**RE: PROPOSED CUSTOMER FULFILMENT CENTRE,
HORSLEY BUSINESS PARK NSW 2164**

LIST OF PROPOSED DA CHANGES

- Drawing: 'Overall Site Plan' Drawing Number: DA020/Rev D
- Drawing: 'Overall Site Plan' Drawing Number: DA020/Rev E

Figure 1: CFC Site Plan

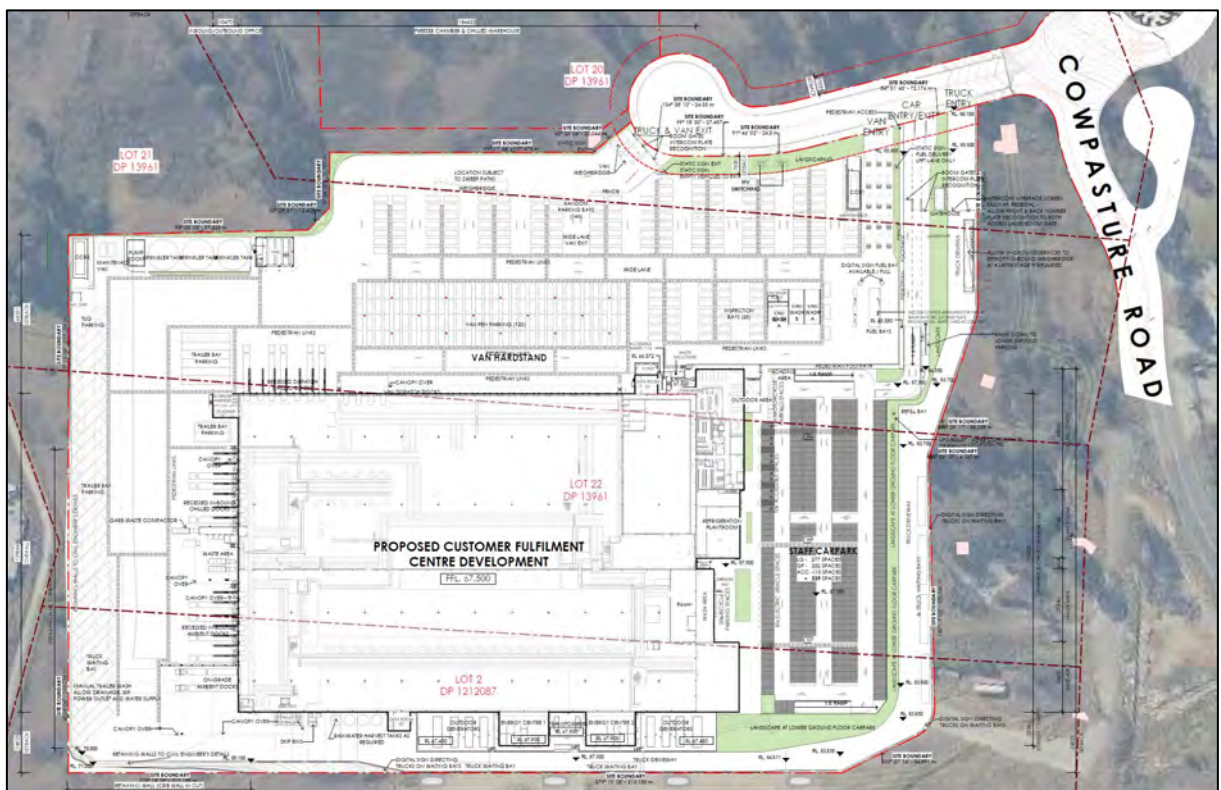
- Fire Sprinkler tanks and pump room relocated to north-west corner of site
- Extra fire sprinkler tank added
- 16 trailer parking bays along north boundary relocated for sprinkler tanks

- CCR1 communication room relocated
- Van Entry driveway widened
- Van Hardstand parking layout altered
- Truck & Van driveway exits combined
- Extra lane added to Staff car park driveway

- Covered pedestrian awning added from street to main office
- Truck weighbridge setback off northern boundary
- Fuel Bay location layout altered in van hardstand

- Van Wash Bays location and layout altered
- CCR2 communications room relocated from southwest corner of site to northwest corner
- Battery Disposal Cage shifted south

- Truck trailer parking and truck waiting bays along western boundary rotated 45 degrees
- Waste room on west façade deleted and altered to waste finger dock

- 6 trailer bay parking spaces added to northwest corner of building
- VI Hut, Data Room 1, external access stairs and ramps altered on north façade
- Outdoor dining area off main office shifted south

- First Floor Main Office façade altered above main entry to provide weather protection
- Loading bay added to staff car parking northern end

- Security turnstiles and access gate added separating van hardstand from pedestrian walkway
- Pedestrian covered way added along west side of staff car park

- Covered bicycle parking added
- Covered smokers hut added
- LPG Bullet added. Located between staff car park and east boundary truck driveway
- Gas Bullet refuel parking bay added

- 4 truck waiting bays added along east boundary truck driveway
- Energy Centres 1 & 2 layout and configuration altered
- Truck driveway gradient along southeast corner boundary altered to keep height of retaining wall on south boundary to 3m maximum

- Data Centre 2 relocated from east façade to south façade
- Rainwater harvest tanks added along buildings south façade
- 4 truck waiting bays deleted from southern driveway adjacent building.

- 2 truck waiting bays added along south boundary truck driveway
- Extent of canopy extended in southwest corner of building to shelter pallet storage area
